Development Facilitation Team (DFT) – Review Comments

Project No: PR-2020-004024

DHOWVR-2025-00012 – DHO PARKING WAIVER

REQUEST: Parking Waiver for Self-Storage Facility

LS 101

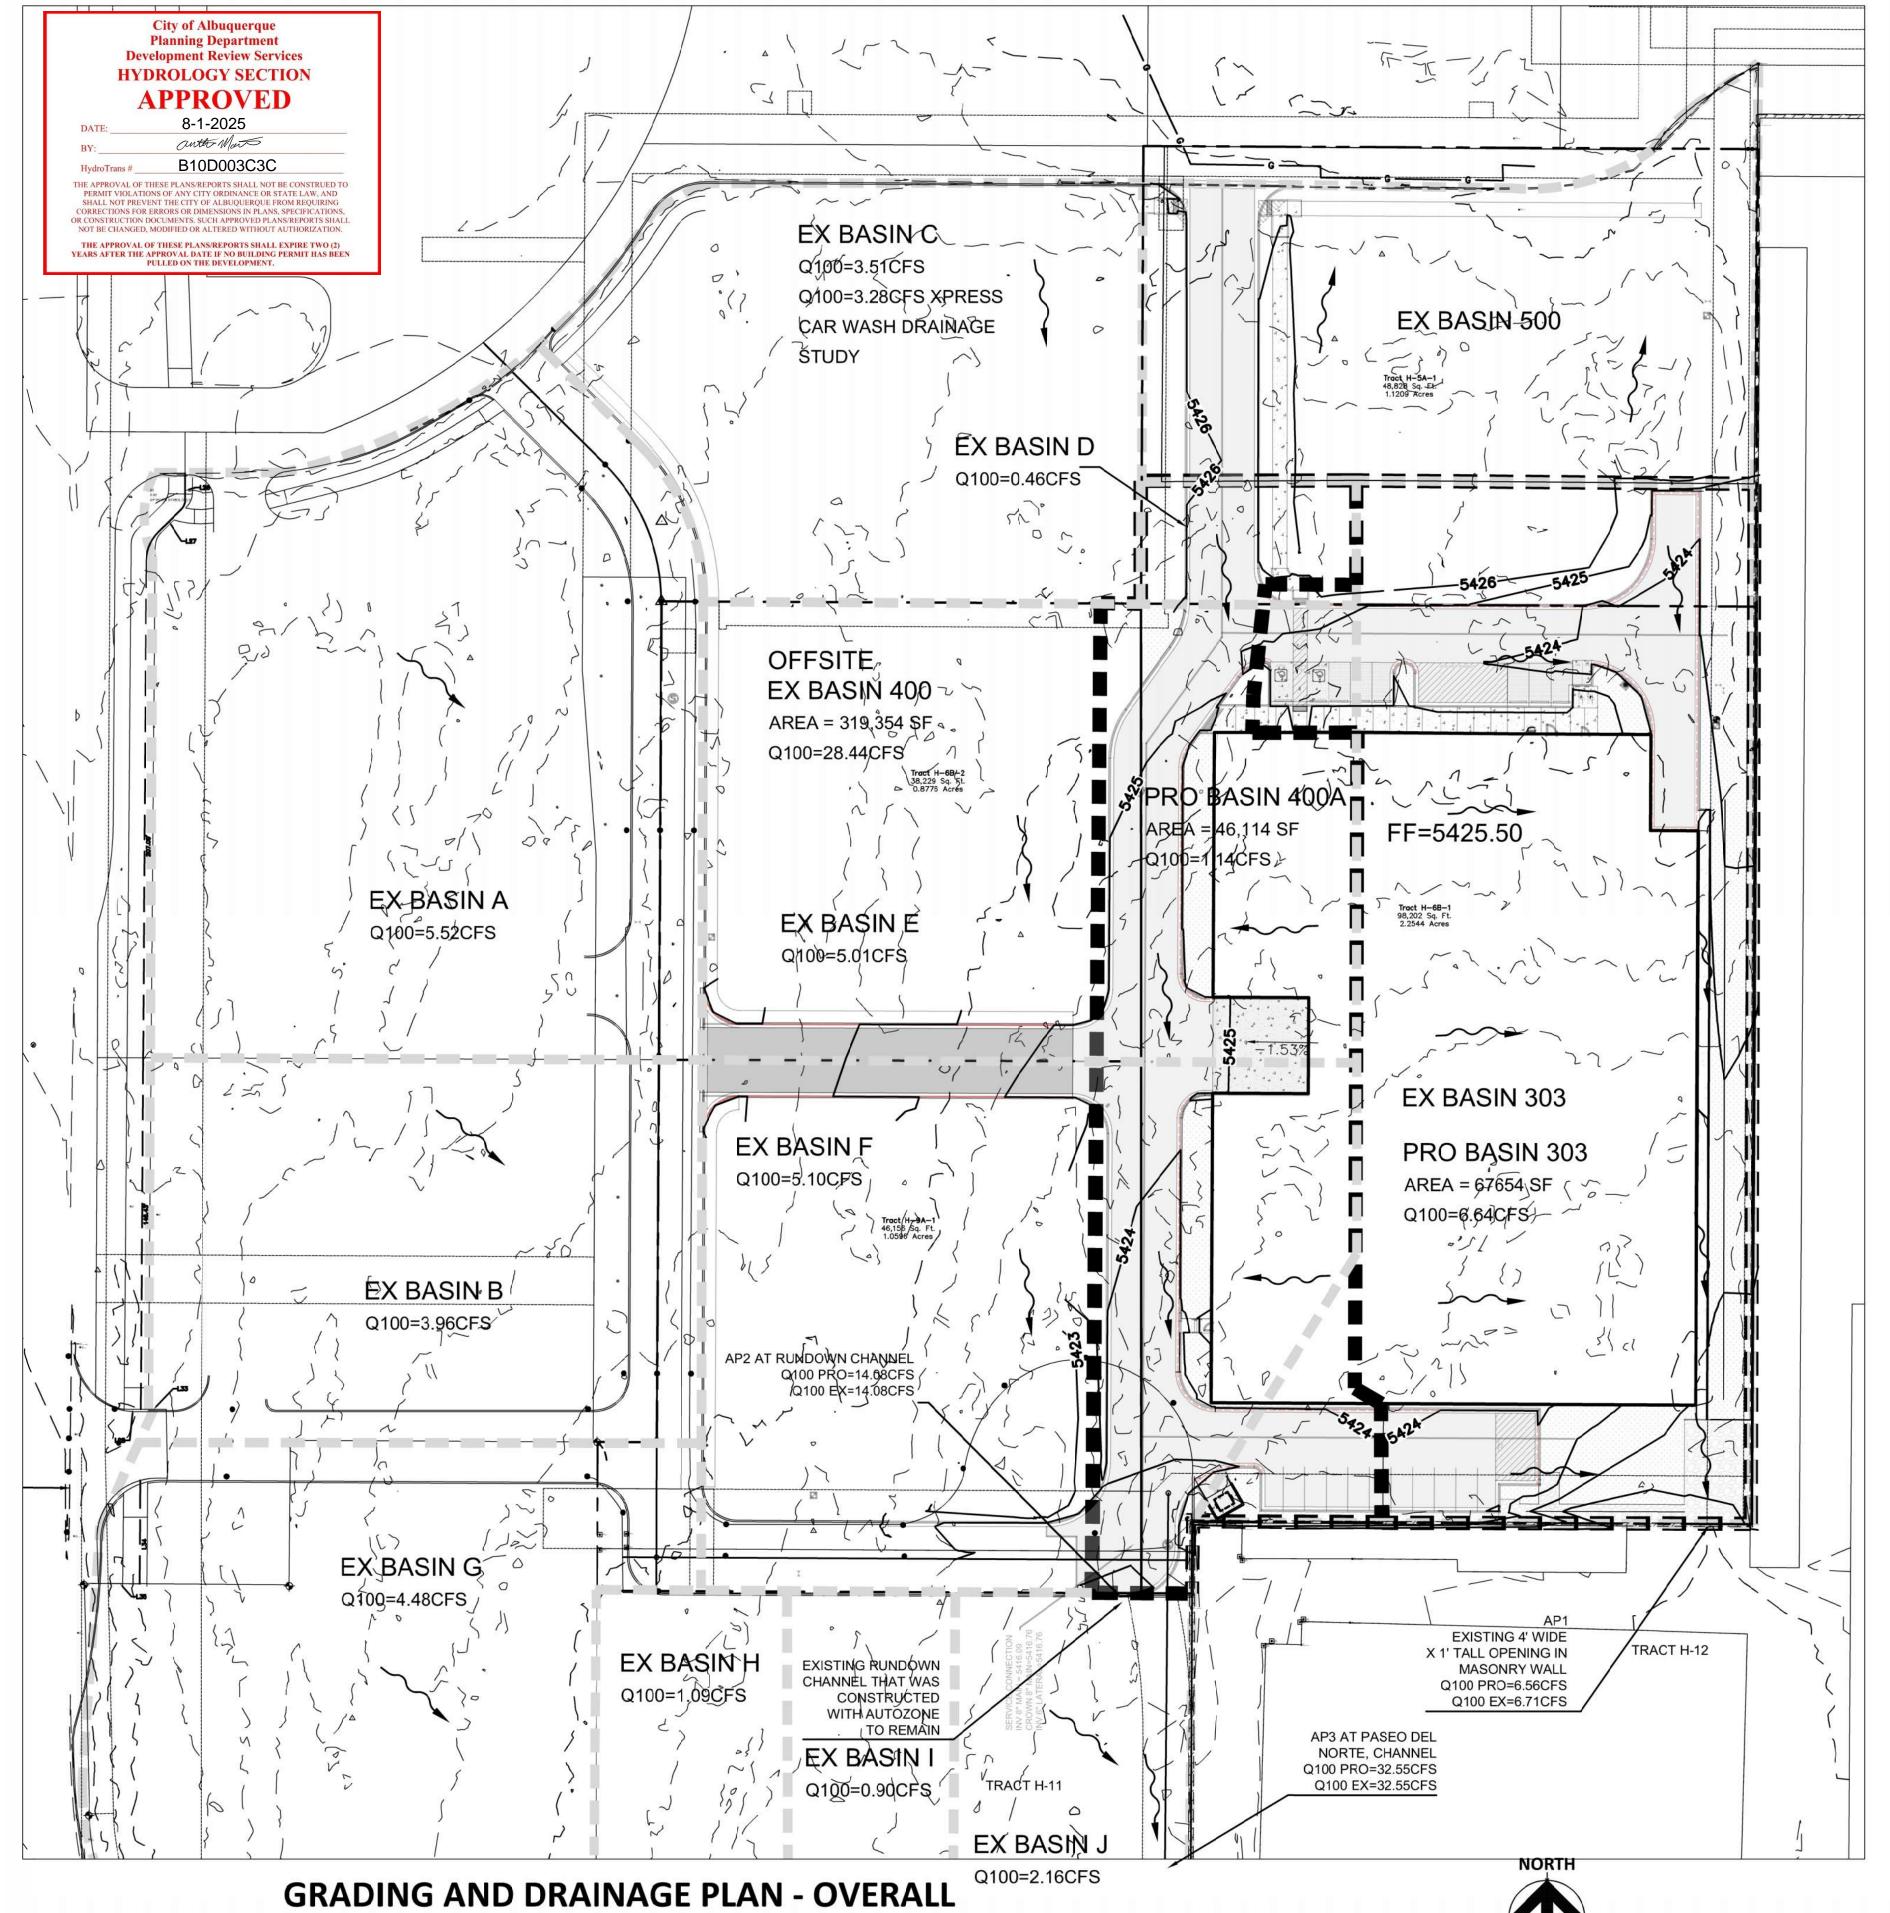
2. Landscape requirements are greatly reduced and two large landscaped areas are replaced by the building expansion and the traffic access lane on the east side of the expanded structure. Need to provide the revised

Landscaping Plan with calculations to show how they would not be deficient in meeting requirements due to change in parking and traffic design.

TRAFFIC CIRCULATION LAYOUT

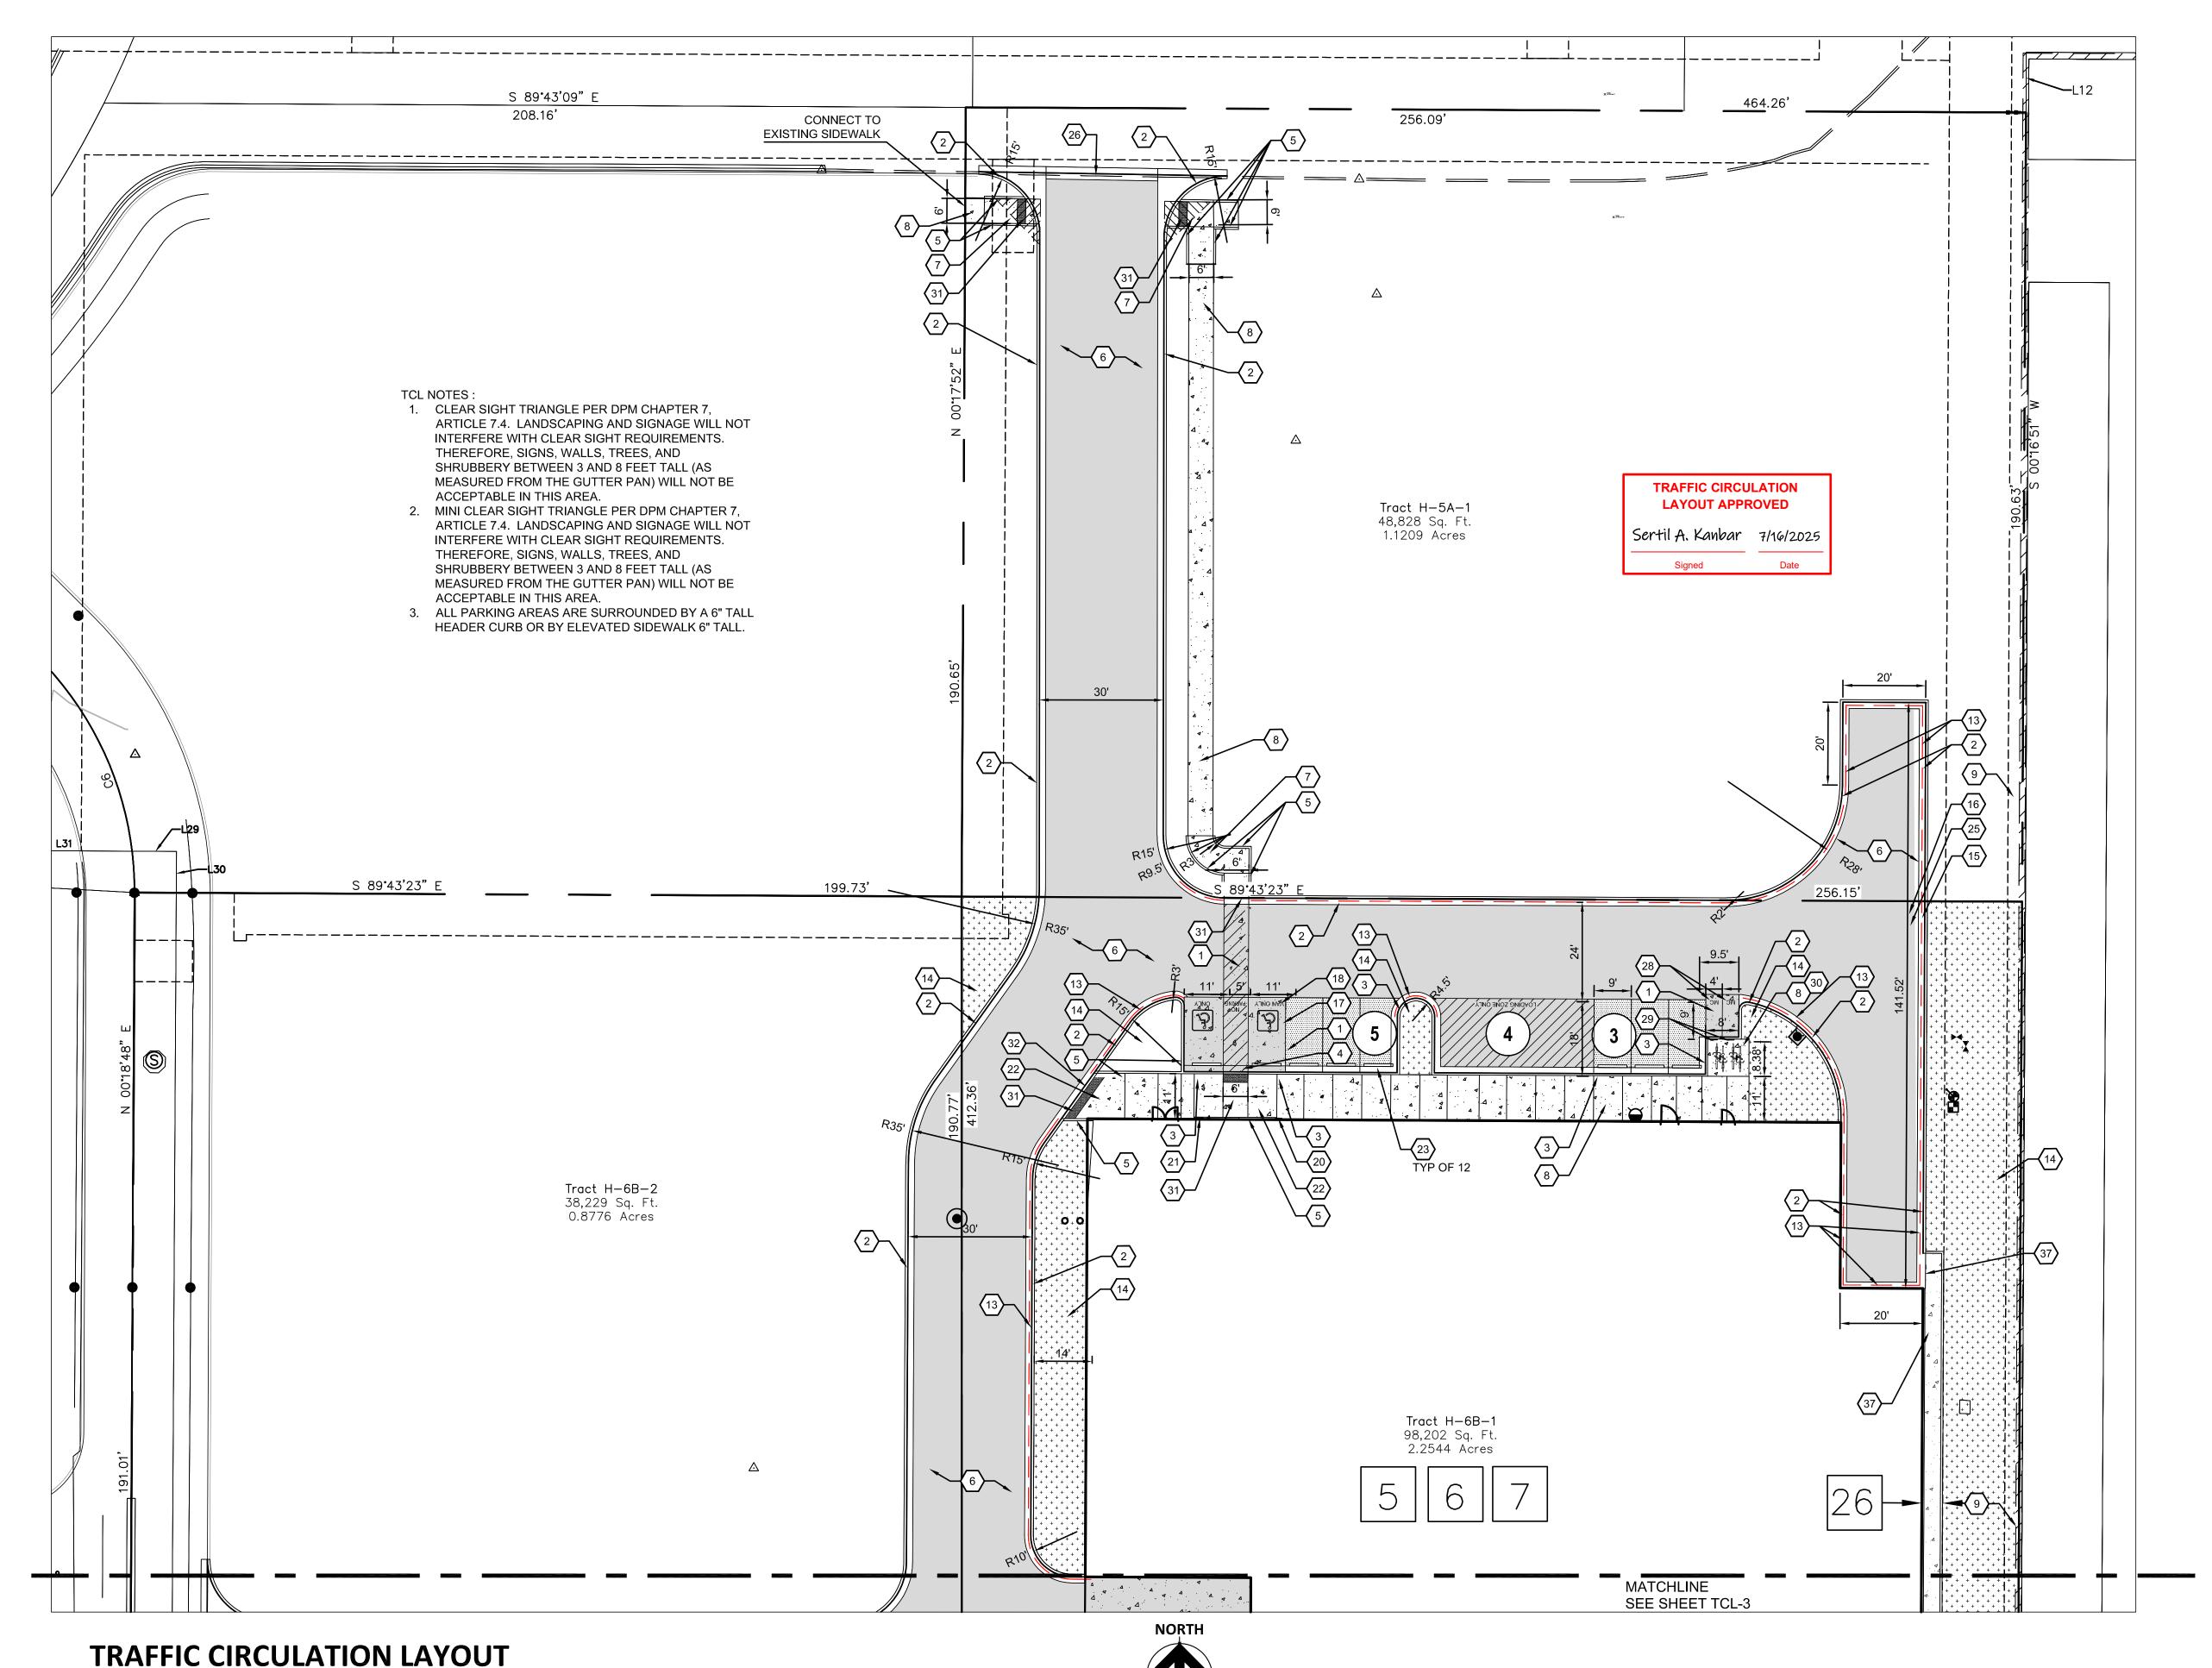
1. Transportation has an approved Conceptual TCL dated 3/21/2024. Changes to the parking and/or building layout will require a revised TCL approval.
2. The application does not do a good job of explaining why this waiver should be granted and that the required number of spaces should not be enforced.
3. Future development will require a full TCL prior to Building Permit.
